East Anglia One North (EA1N) and East Anglia Two (EA2) Offshore Wind Farms

Deadline 12 – 28 June 2021

**Comments of Suffolk County Council as Local Highways Authority**

**Outline Operational Drainage Management Plan (AS-126)**

## Appendix 2: SuDS Outfall Concept Design to the Friston Watercourse

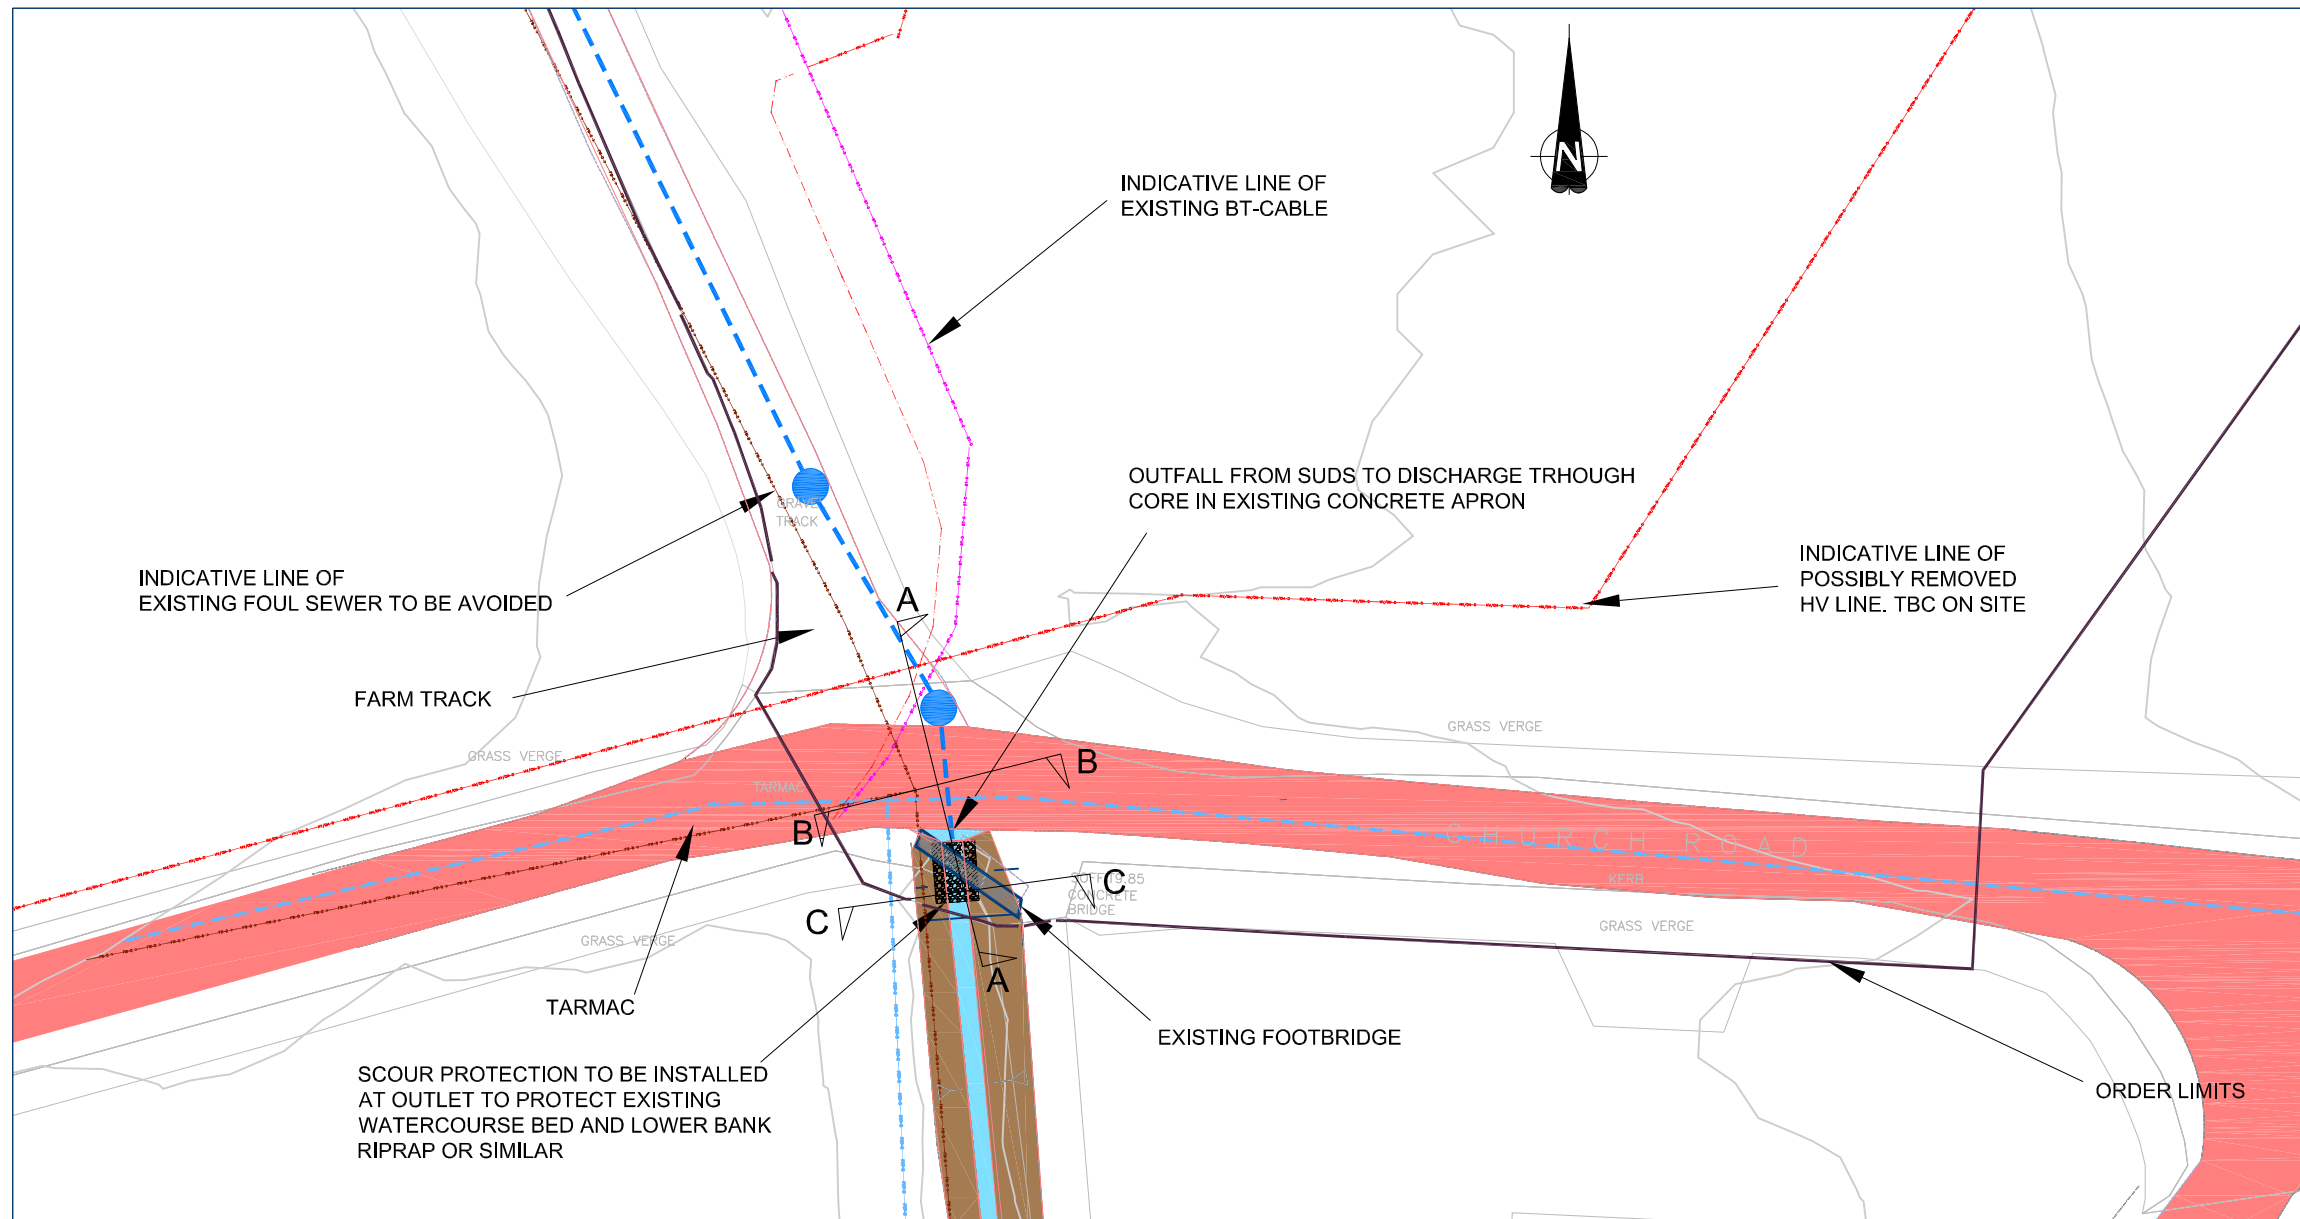
3.6 The LHA has requested that the nominal depth of cover between the pipes discharging water from the sub station site to the Friston Watercourse and the surface of Church Road are shown on drawing ED11892-GE-3016 and described in paragraph 5.3.3 of the Outline Operational Drainage Management Plan. During discussions with the applicant the LHA has been advised that the pipes are approximately 300mm below existing road surface which would be acceptable to the LHA subject to agreement of suitable detail design. We understand this position is also stated in LA-10.44 in the Statement of Common Ground Version 5 to be submitted at deadline 12.
